**BOTLEY WEST SOLAR FARM**  
**OXFORDSHIRE HOST AUTHORITIES**  
**Response to SoS Request for Additional Information**  
**09 June 2026**

Botley West Solar Farm (EN01014)

### **Purpose of this Submission**

Trenching Within Root Protection Areas

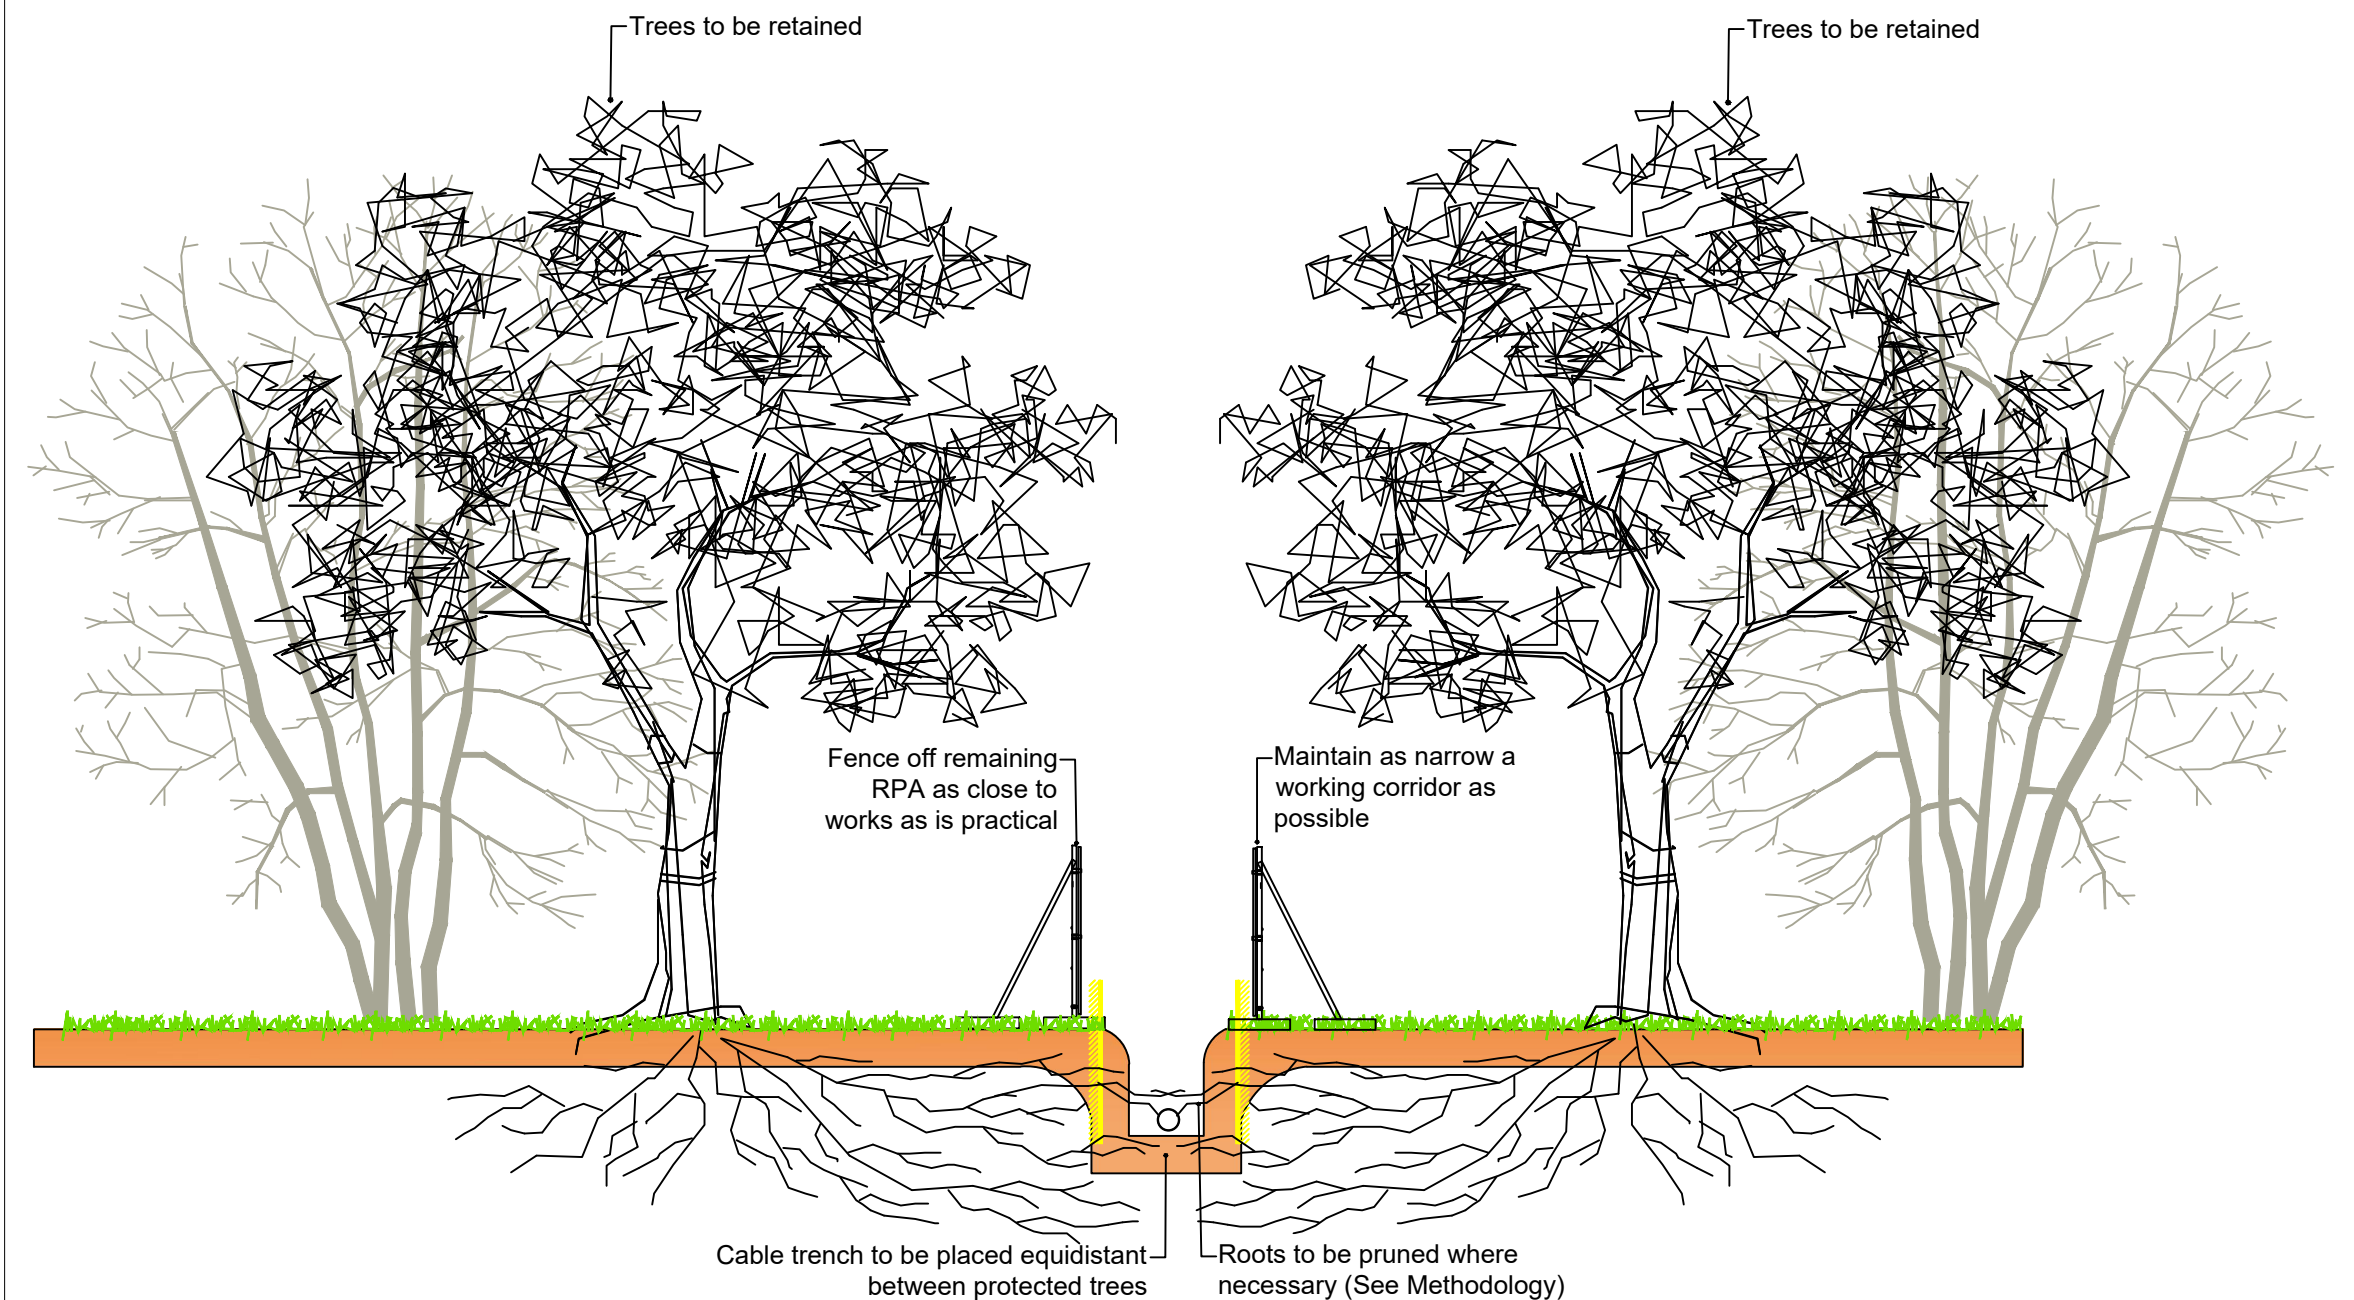
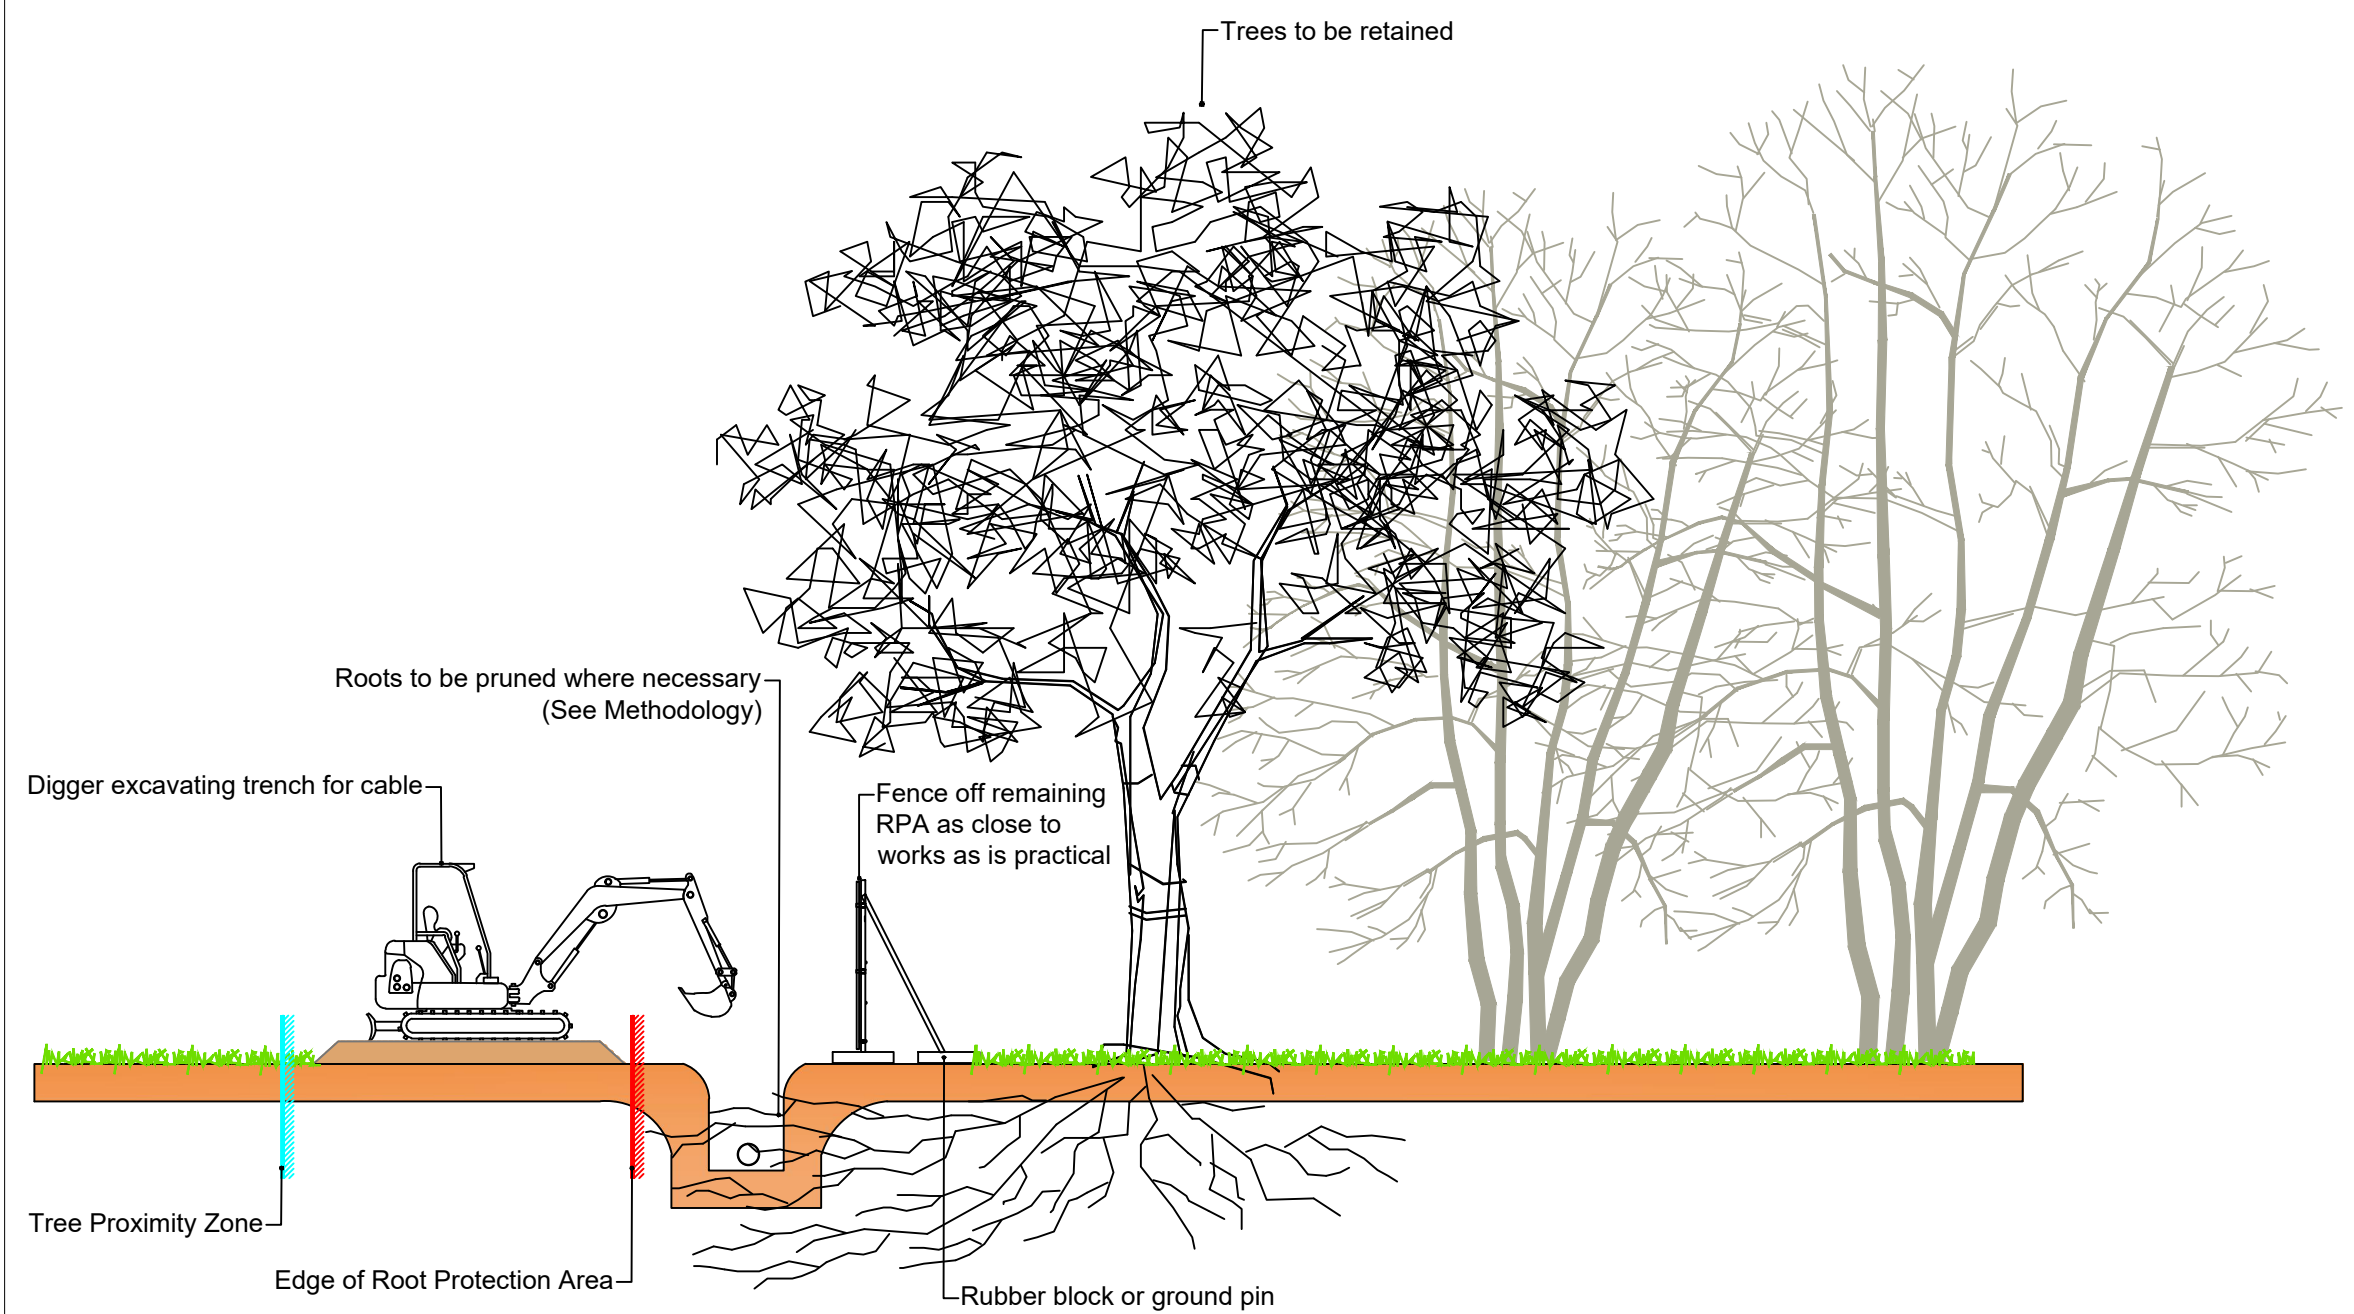
<p>have concerns about the use of the Strip Foundation scenario within root protection areas.</p> <p>31. Para 6.1 of the Tree Protection Protocol (Appendix C) [REP6-018] states that trenching within the RPA of retained trees shall only be carried out if absolutely necessary. Any proposed work that will require trenching within RPAs shall first be assessed to see if it can be diverted in order to protect trees. The OHA wish to understand how and when this will be decided.</p> <p>32. For HDD 11 the OHA have determined that the applicant is likely proposing Scenario 6, for works in relation to a Veteran Tree. A clearer representation as to whether trenching is proposed in the root protection area or the buffer area would be helpful, although we acknowledge and agree with the SoS that the Strategic Arboricultural Impact Assessment &amp; Method Statement should be updated to state that there will be no trenching in veteran tree Root Protection Areas. This would allay the concerns of the OHA as to whether the appropriate scenario would be implemented. The OHA consider that the mitigation hierarchy should be applied; any proposed works within the RPA of veteran trees and above is unacceptable and should be avoided.</p> <p>33. The Tree Protection Protocol Scenario 6 is not acceptable. Using machinery to excavate within RPAs is likely to lead to excessive and adverse arboricultural impacts, contrary to section 7.2.1 of BS 5837:2012 which states ‘To avoid</p>

<p>damage to tree roots, existing ground levels should be retained within the RPA. Intrusion into soil (other than for piling) within the RPA is generally not acceptable, and topsoil within it should be retained in situ. However, limited manual excavation within the RPA might be acceptable, subject to justification. Such excavation should be undertaken carefully using hand-held tools and preferably by compressed air soil displacement’. NJUG Volume 4 also provides guidance for installing utilities within proximity to trees.</p> <p>34. The methodology is not clear as to how trenching will be decommissioned at the end of the project. Will it involve any soil improvement? The OHA require clarification as to how trenching will be rectified at the decommissioning stage.</p> <p>35. The OHA agree that clarification is required on how the potential impacts of HDD will be managed at Crossing Point 3 – The OHA assume that scenario 10 would be implemented as the cable route would follow the road or verge, but appears to cut directly through the RPA of several notable trees identified by the Ancient Tree Inventory.</p> <p>36. Scenario 10 appears to be the likely method to be implemented at HDD9, following the road or verge, but is directly cutting through what would be the RPA of tree T71. It would be useful to understand the specification of how deep the cables will go in this section, if it will go under or through the road. If breaking out of hard surfaced areas is to be</p>
